Please ask for: Ms Iqraa Malik
Email: iqraa.malik@terraquest.co.uk
Telephone: 01212341390
Our Ref: AW/55/21/HH
Your Ref:
Date: 17th February 2021

Application for Planning Permission for Works or Extension to a Dwelling

Development: Loft conversion & single storey side extension
Location: 19 Grosvenor Gardens Aldwick Bognor Regis PO21 3EY

BLOCK PLAN 1:200

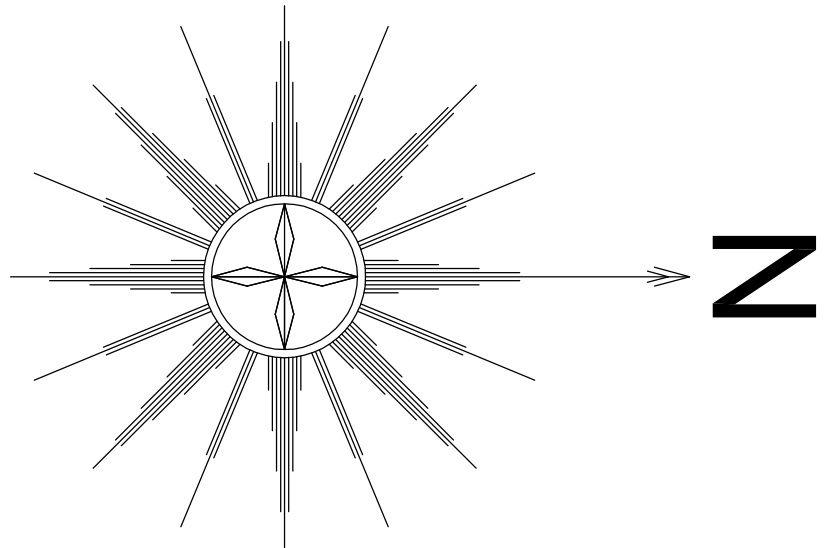
Dimensions: You are required to include dimensions on the block plan from the proposed extension to all site boundaries.
